06 June 2022

Application: CM/27/22/DOC
Location: Bairds Farm Shop Garden Centre Crookthorn Lane Climping BN17 5SN
Proposal: Approval of details reserved by condition imposed under CM/16/18/PL relating to conditions 6-landscape scheme, 7-Travel Plan and 11-external lighting.

Pseudo colours, SITEWIDE (E)

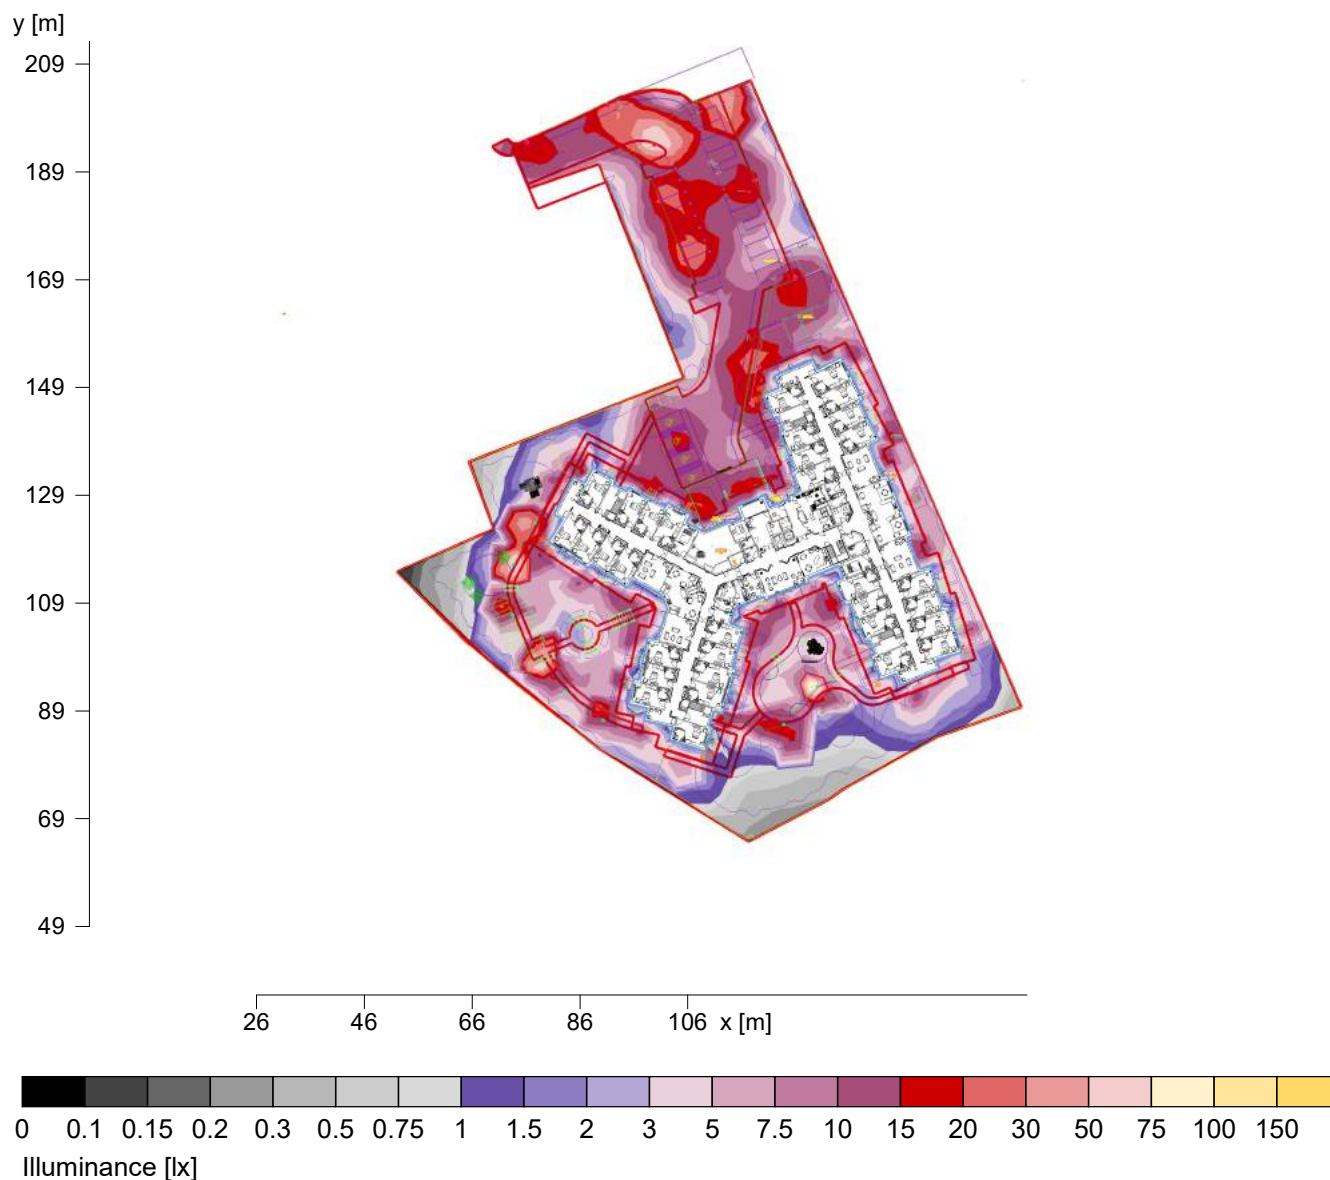
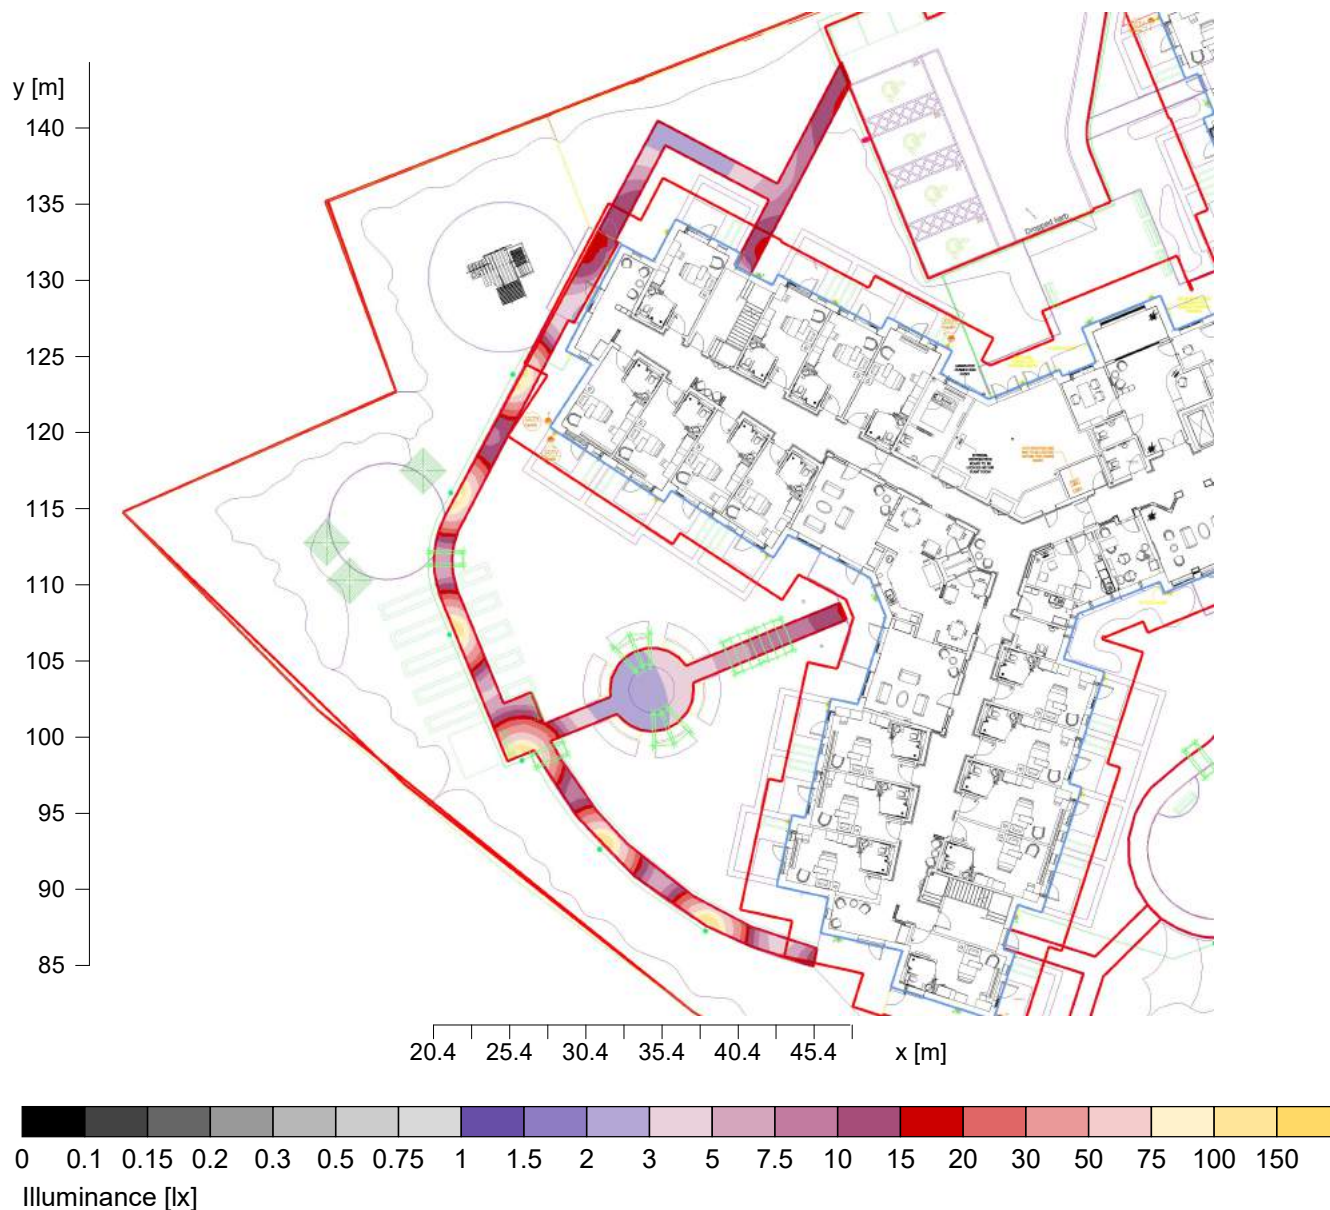
We are satisfied that the submitted information includes the detail required by Condition 11 as shown in the External Works Layout Drawing Number 800 Revision P1 (Monitor Systems, November 2021) and the External Lux Plot (Monitor Systems, November 2021). We note that the lux levels around the south and west boundaries of the development are generally within the range 1-1.5 lux which is below the level which would impact on nocturnal wildlife, including bats. The lighting scheme has therefore been designed appropriately for biodiversity.

Subject to implementation in full, we recommend discharge of Conditions 6 and 11.
